Request for Clarification of Information

Address: 142 Douglass Street

Permit #: 2017-00352

Reviewer: Greg Gilbert

OWNER'S
NICK AND REGINA EREKINE
ADDITION 9' x 10'
LOCATION
142 DEWEETS ST. PORTLAND, OR
SCALE 1/4" = 1'-0" DATE
JAN 12 2017

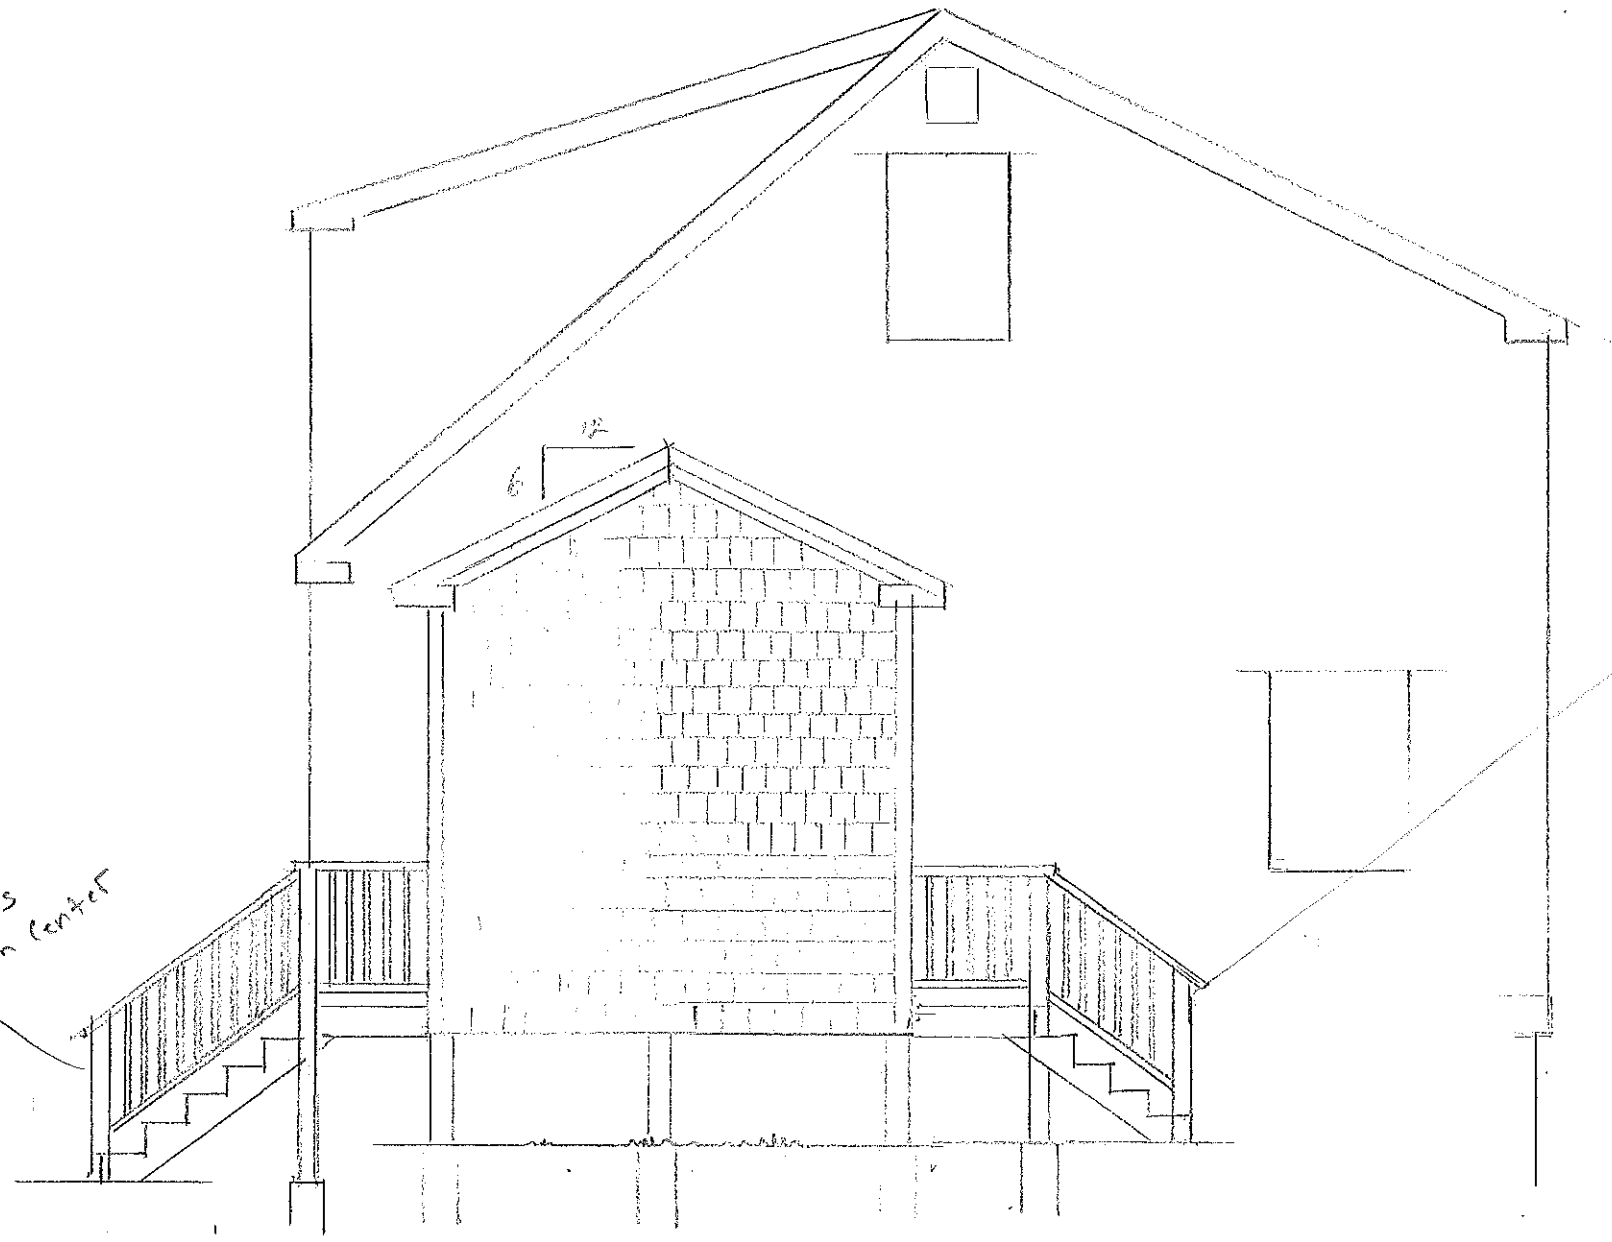
Per section R311.3 the landing shall have a minimum dimension of 36" measured in the direction of travel

What is this dimension
